DEPARTMENT OF PUBLIC WORKS

TO: All Staff
FROM: Public Works Planning Review Team
DATE: November 3, 2020
SUBJECT: VA-20-00010 Fuhr

The Department of Public Works has reviewed the zoning variance application and recommends approval based on the following:

Lot 102 of Hyak
Estates
Unified Site Plan

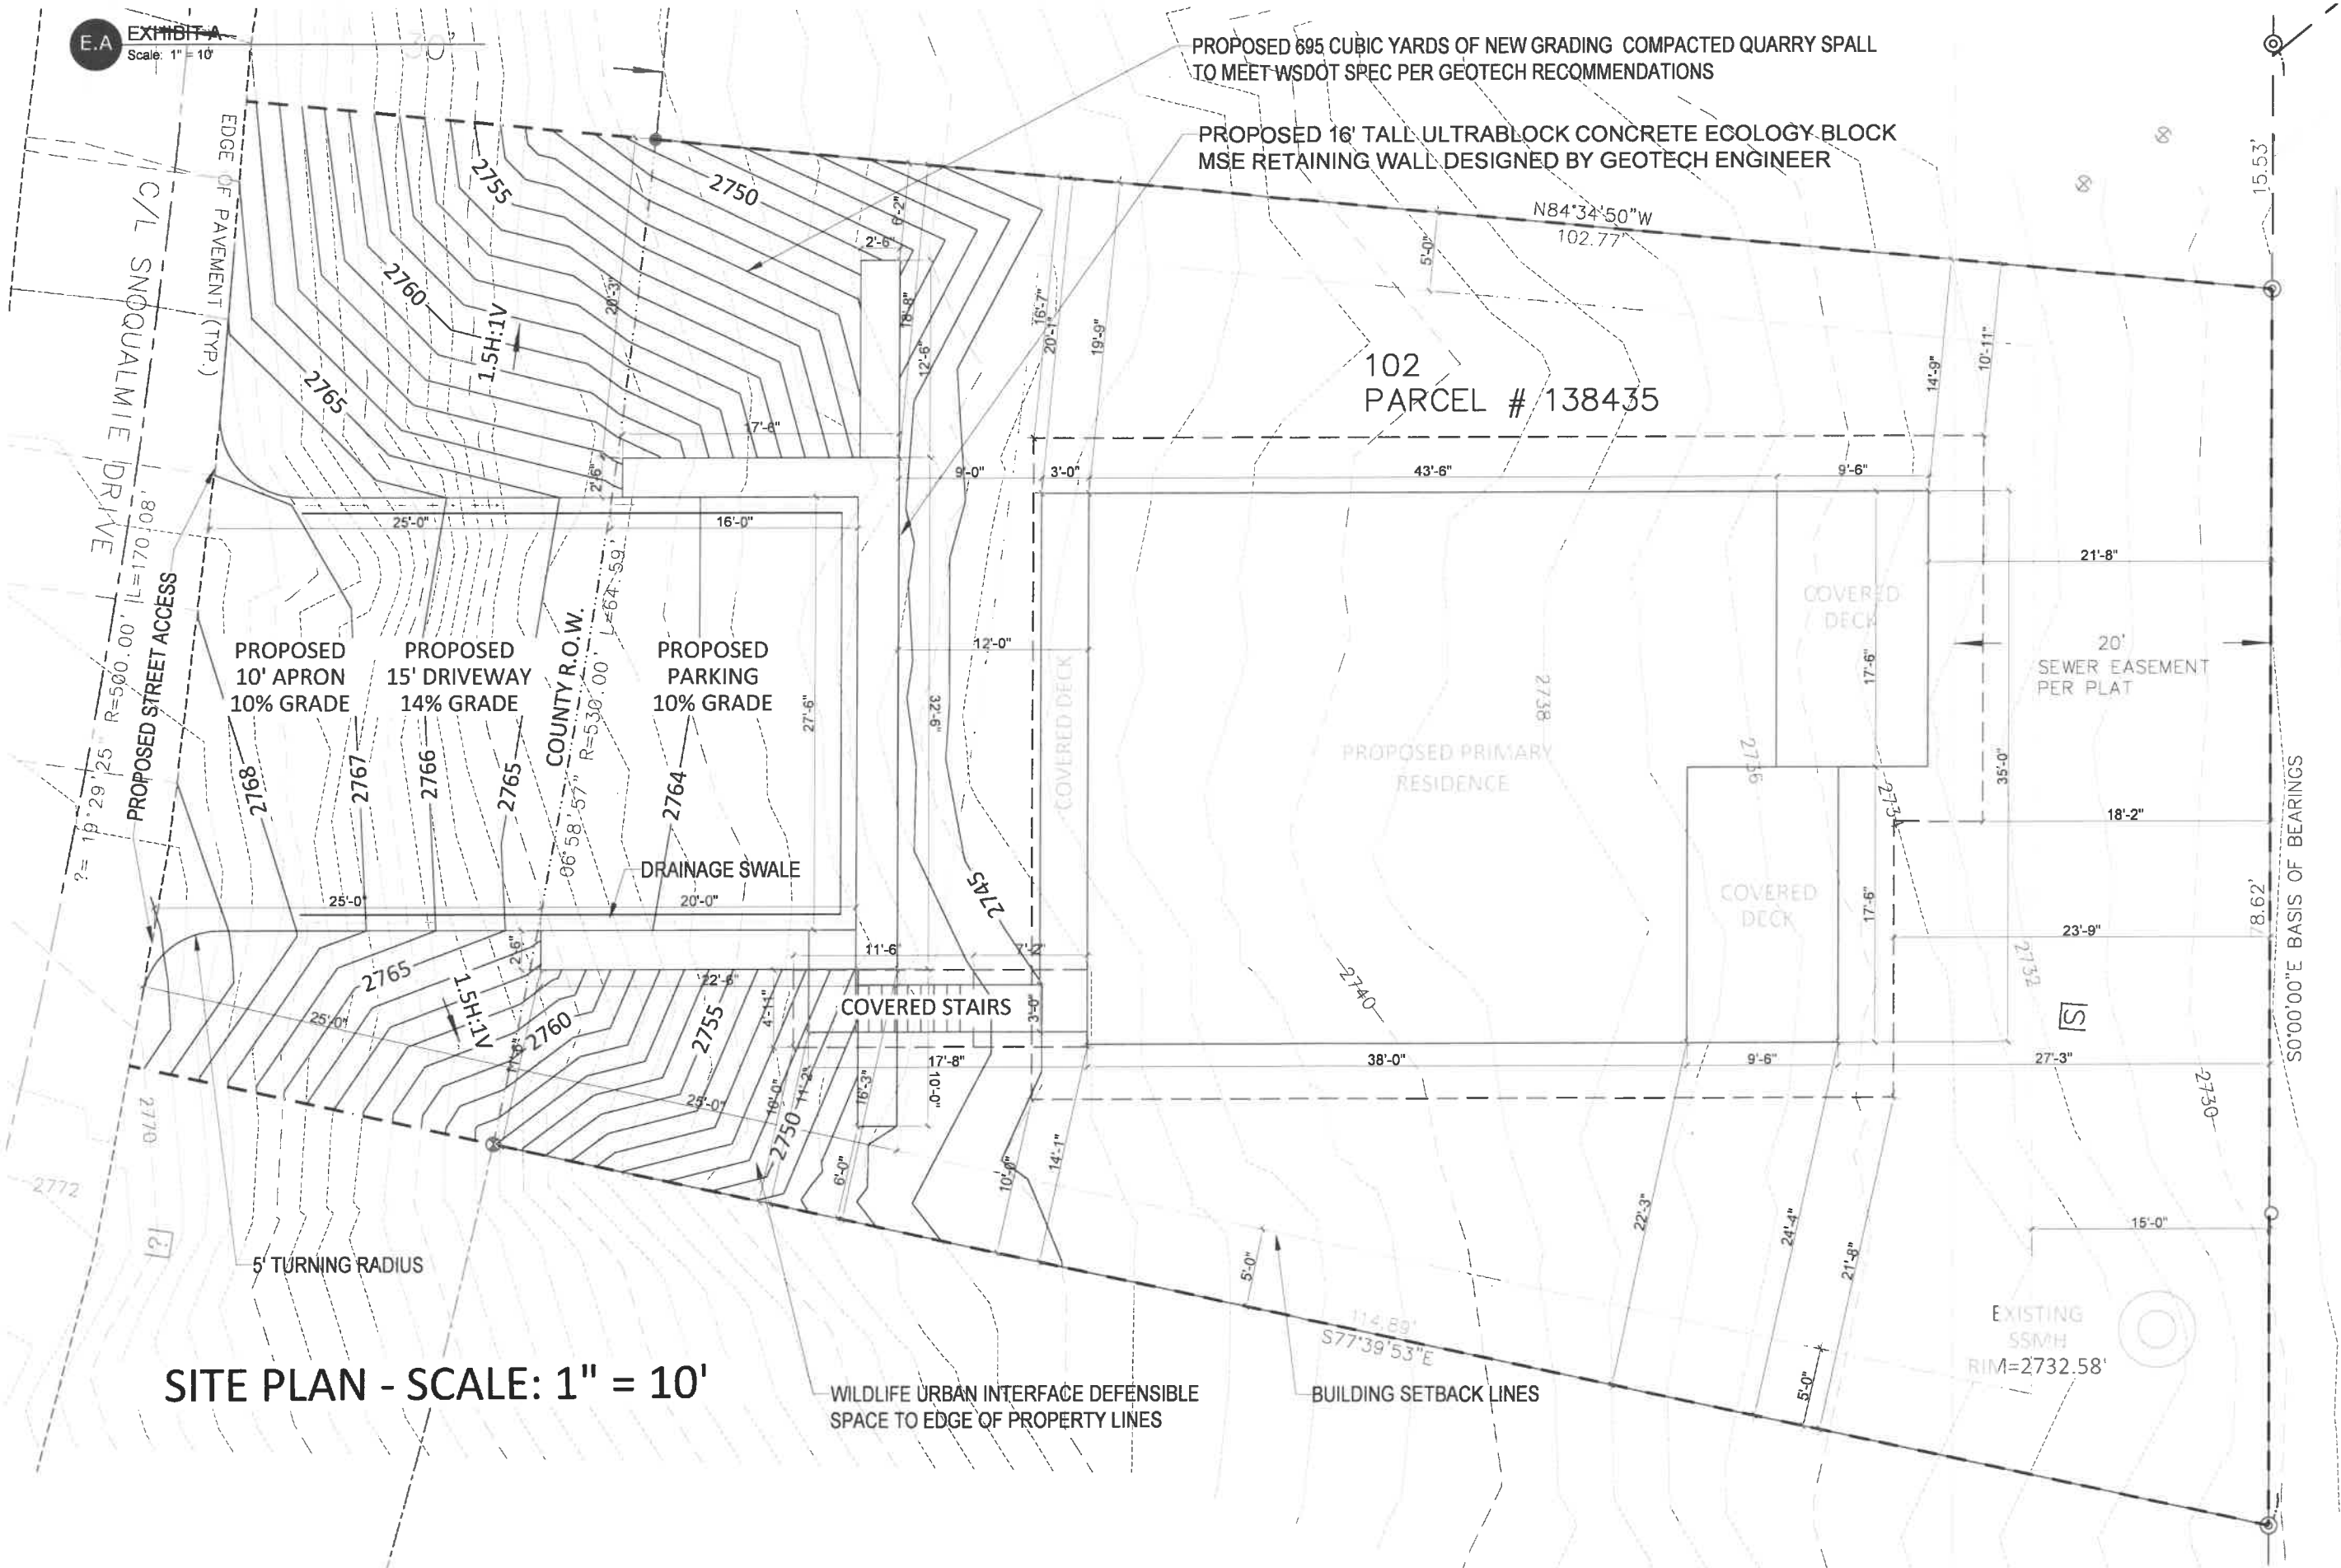
- C. Any grading over 100 cubic yards of material will require a grading permit from Public Works.
- D. The site plan does not explicitly show all of the details called out in the Geotech report. Please be sure to implement the recommendations provided by Icicle Creek Engineering for the wall drainage, retaining wall details, material types used, etc.

- E. Please have the retaining wall certified by the design engineer after construction to ensure it was built to the plan outlined shown in the geotechnical report.

- F. With the 16' drop off on three sides of the wall please implement a barrier to protect vehicles and pedestrians from the vertical drop off.
- G. The contours design contours show that this design will alter the existing drainage by pushing water onto the neighboring properties. Please adjust the grading or provide other BMPs to prevent increasing runoff onto the neighboring lots.
